CITY OF ALBUQUERQUE

PLANNING DEPARTMENT – Development Review Services

October 5, 2015

**RE: New Office Warehouse for Purvis Industries (E17D041F)
Singer Blvd. & Midway Park Blvd.
Conceptual Grading and Drainage Plan
Engineer Stamp Date: 9/2/15**

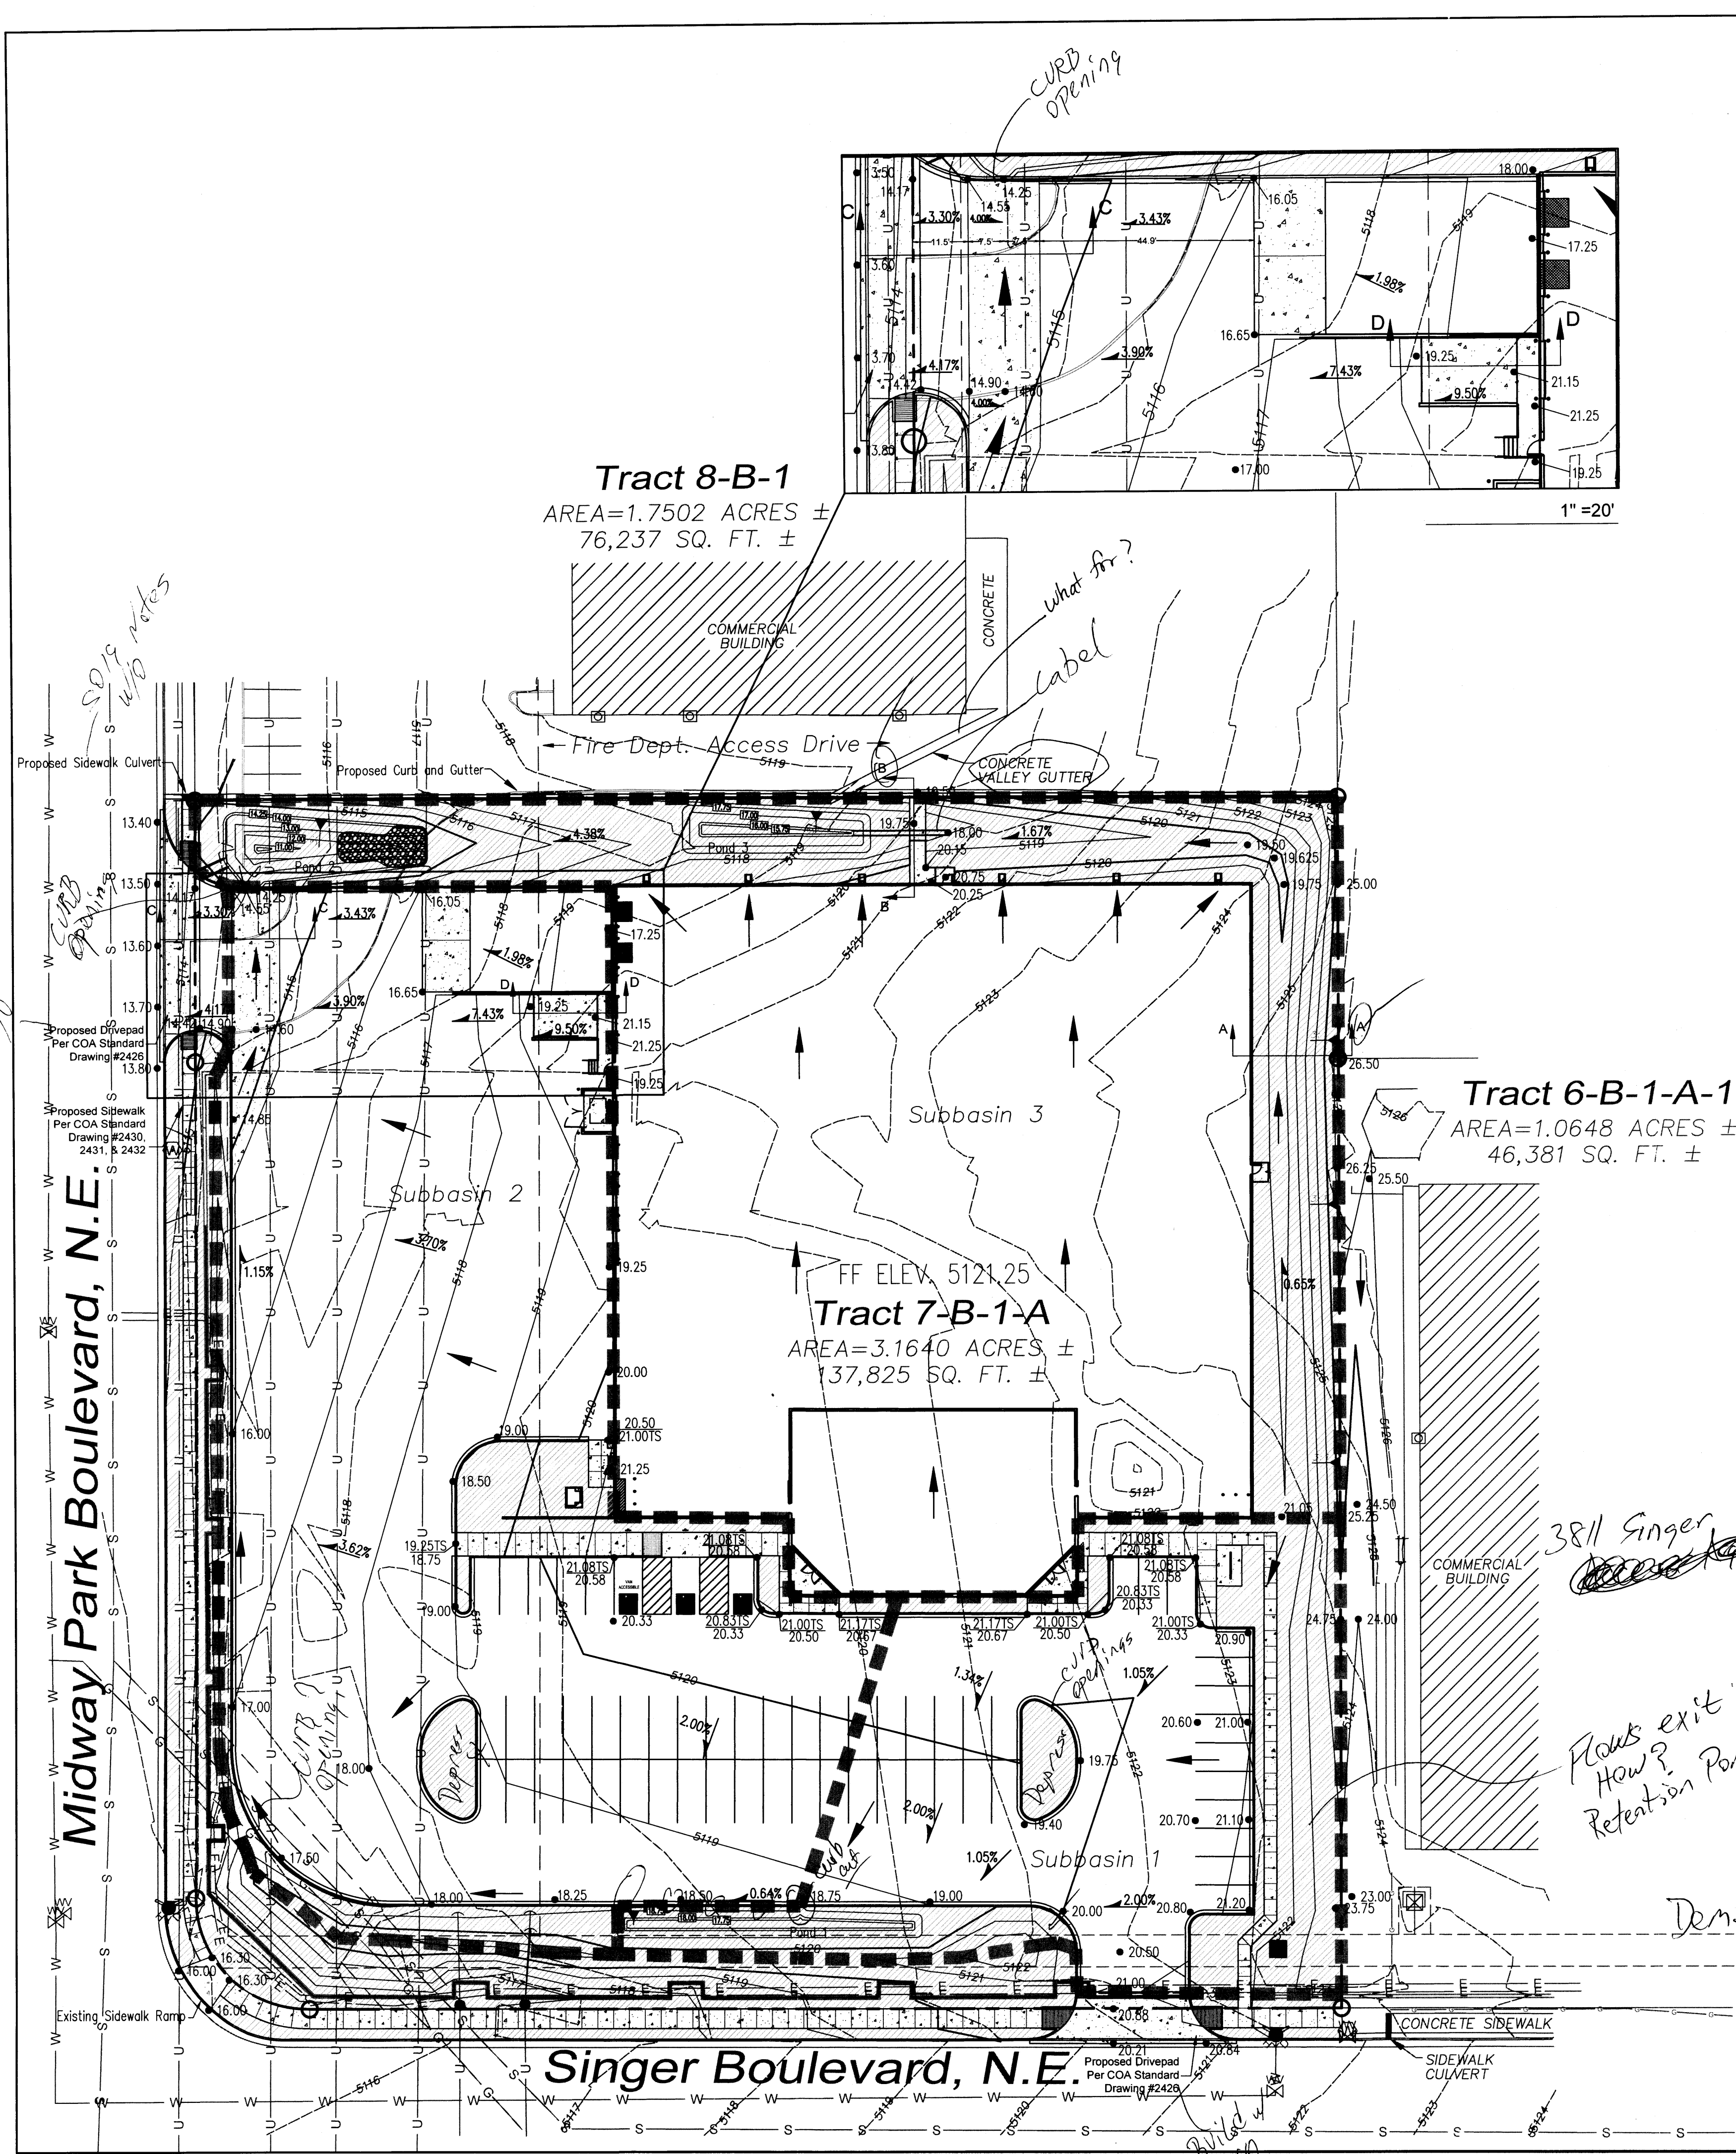
4. An exhibit showing existing and proposed lot lines would be helpful. Also show existing building, and indicate those intended to be demolished.
5. Provide information or excerpts from the lots to the east (F17D058 and F17D054) to determine how the drainage of these lots will be directed south through the new swale. The last paragraph of the narrative should be labeled "OFFSITE FLOWS" and be presented before "Proposed Conditions" in the narrative. Since existing off site flows to the east are intended to flow south to the existing SW culvert, show that the swale and existing SW culvert have sufficient capacity.

12. Call out the 18" pipe culvert on the plan view. Is there sufficient cover for this culvert?
13. Show erosion protection between Pond 2 and 3.
14. If drive pads or other infrastructure is intended to be built via Work Order, indicate so with a note. Otherwise all drive pads must be sufficiently detailed on the grading plan (quarter points, flowline elevations, etc.)

17. Provide a FIRMette or a description of the flood zone and what map the info came from.
18. Provide a bench mark.
19. Provide build notes/details for the 3' x 0.5' concrete weir at Pond 2.

COMMISSION No. 15-121
DATE 10-2015
REV 10-2015
SHEET: C-1
1 OF 4

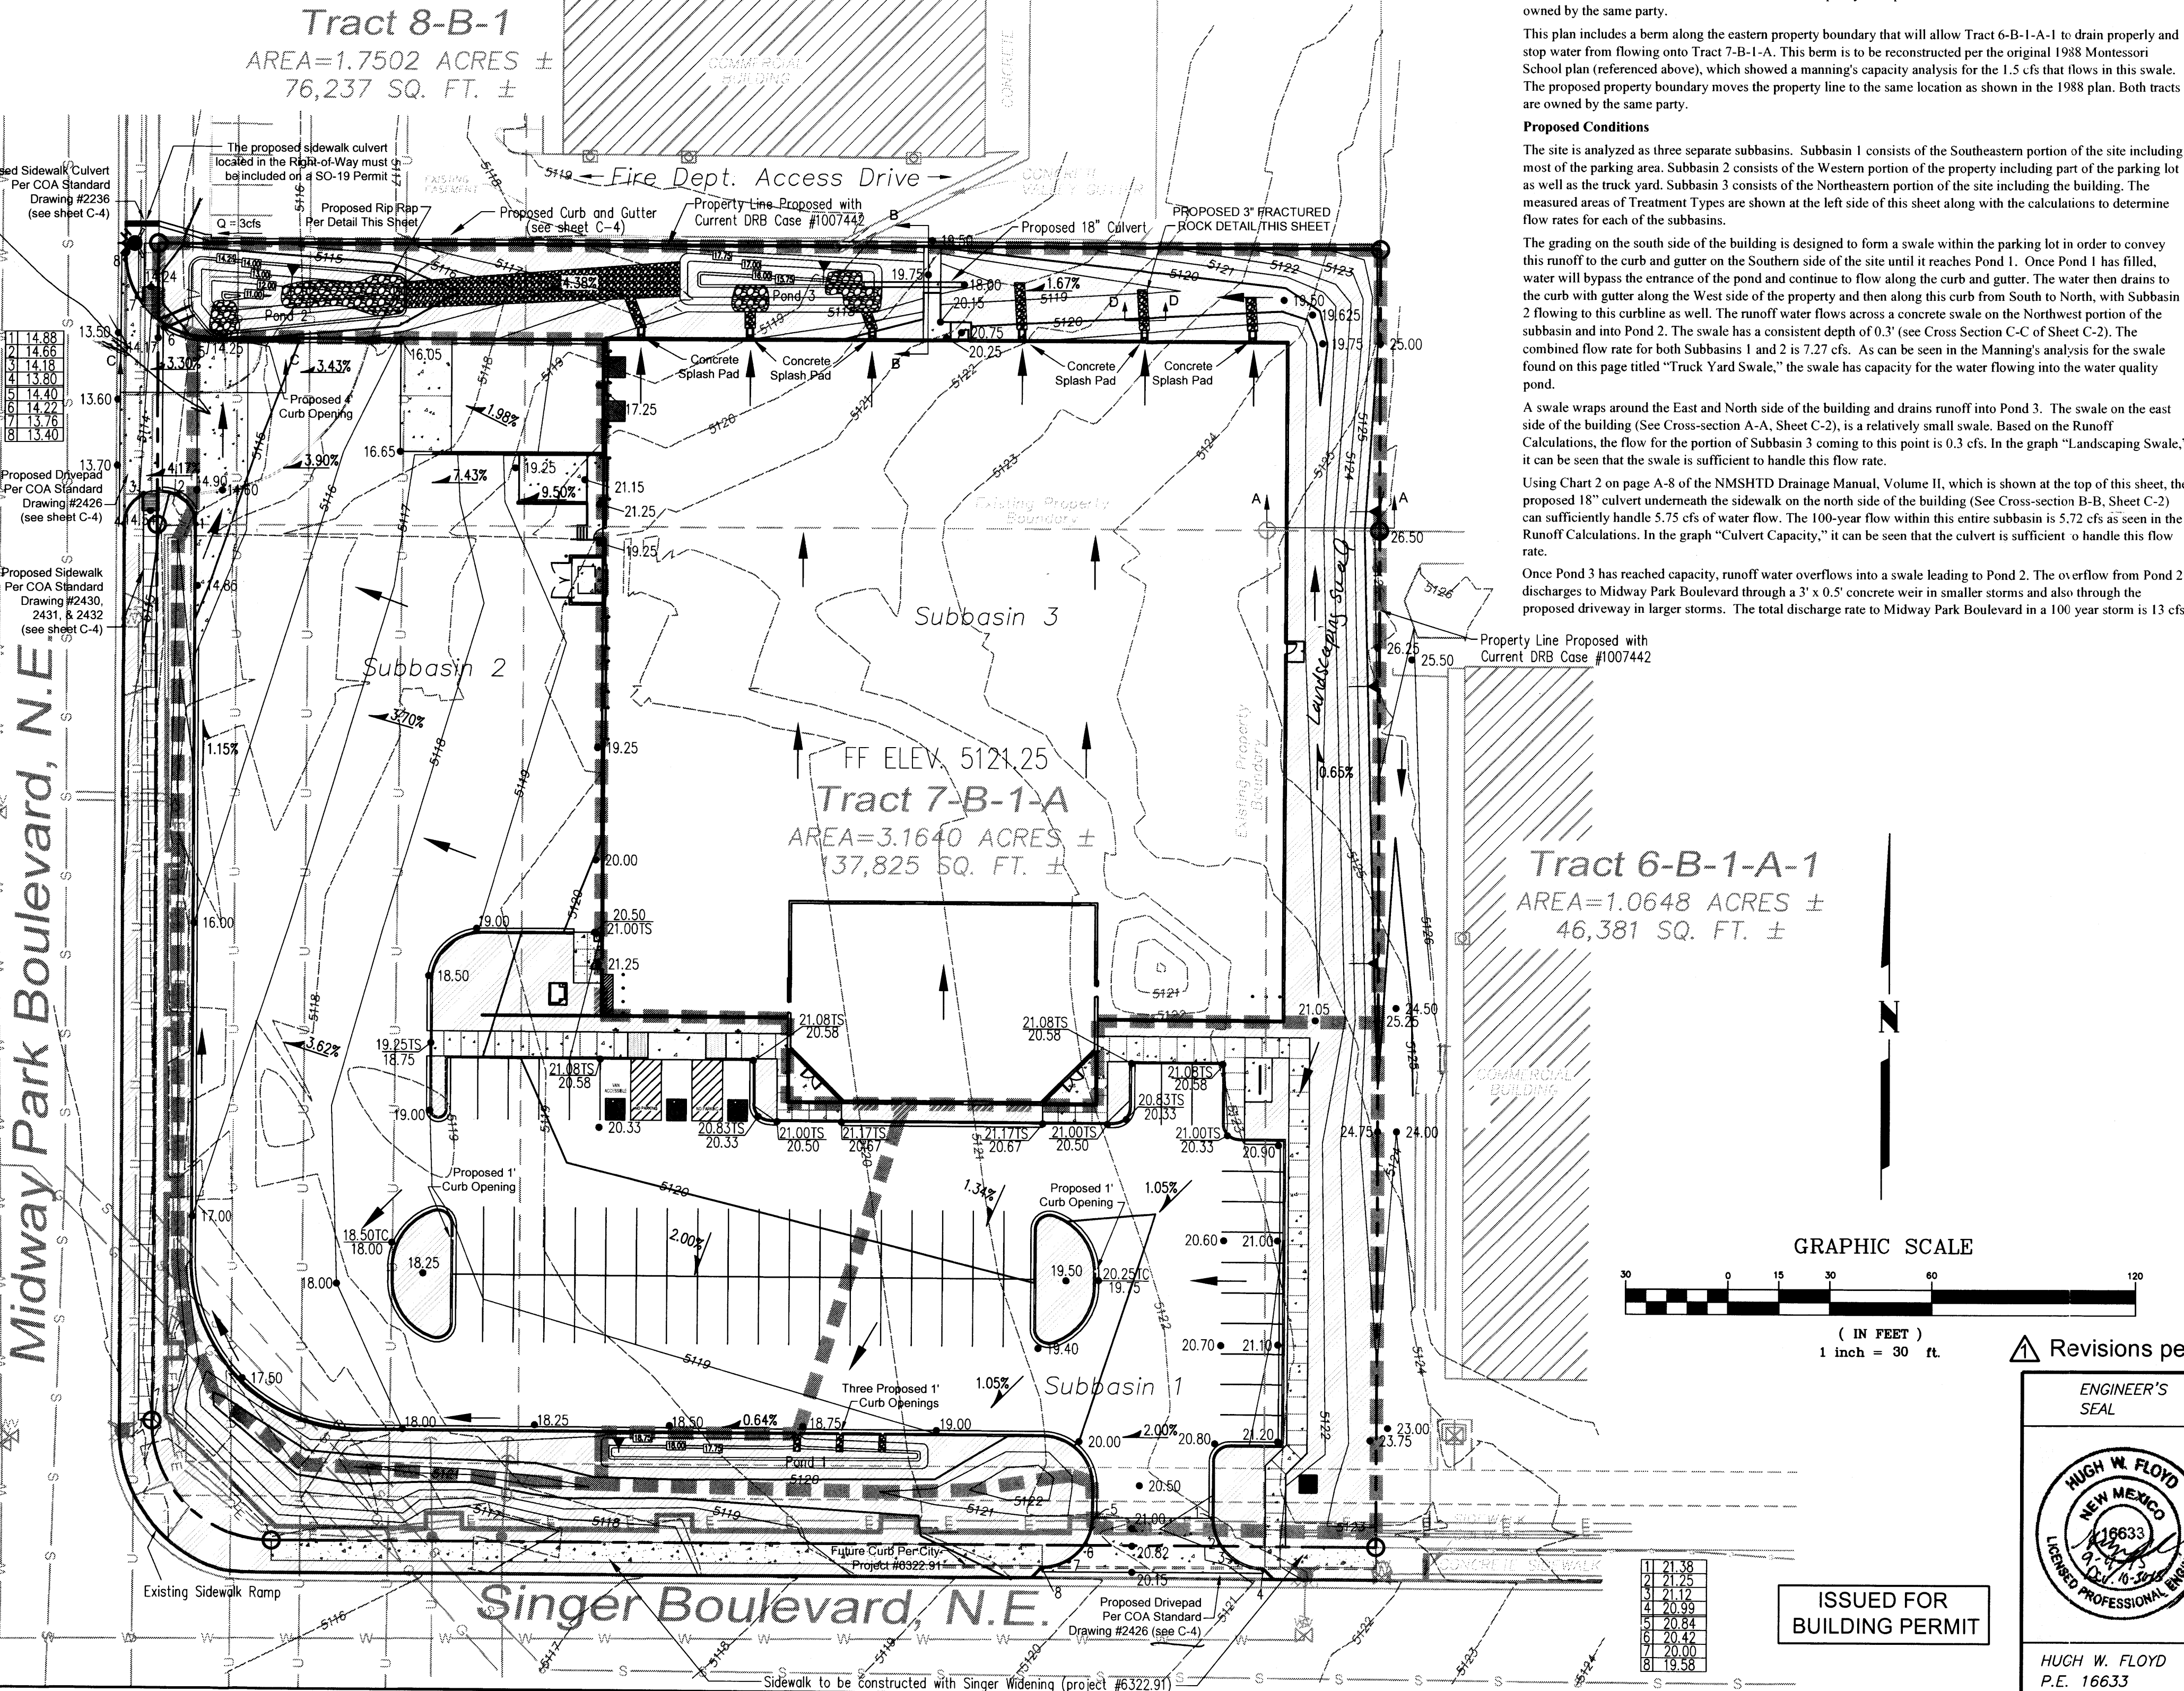
1. In the narrative, indicate the Drainage File number of all reports that are used to research this site, ie. Singer Business Park DMP is E17D041F; Montessori School is also E17D041F

2. The Singer Business Park Drainage Plan (1984) is missing basin maps but the narrative explains the drainage scheme and this information should be summarized in the narrative. Indicate how basins 1-B and 2-B were intended to drain, and how flows ultimately discharged to Midway and then to a channel. Also state the developed discharge from this site, as the downstream channel would have been sized based on this amount.

3. The Montessori School Drainage Plan (1989) is referenced in the narrative and states that the site was developed according to the plan. However, comparison of aerial views to the plan do not match. What portions of this plan were constructed? How do present day lot lines compare to those of this plan? What happened to the concrete alley gutter which accepted flows from the lot to the east? It is not evident in the aerial view? How much flow did it accept? What was the discharge?

7. Provide calculations to determine the amount of First flush that must be retained for each sub-basin.

8. Calculations for concrete swale at NW entrance show 0.3 cfs, but the peak flow rate is 7.27 cfs. Verify the swale is sized correctly.
9. Pond Volume calculations need only be to 2 significant digits.

10. How will the "first flush" from Sub-basin 1 enter Pond 1? Show openings intended to direct flows to both Pond 1 and 2.
11. Show rip-rap or concrete pads below roof drains, and show how discharge will either be directed to Pond 3 or the swale on the east side of the pond.
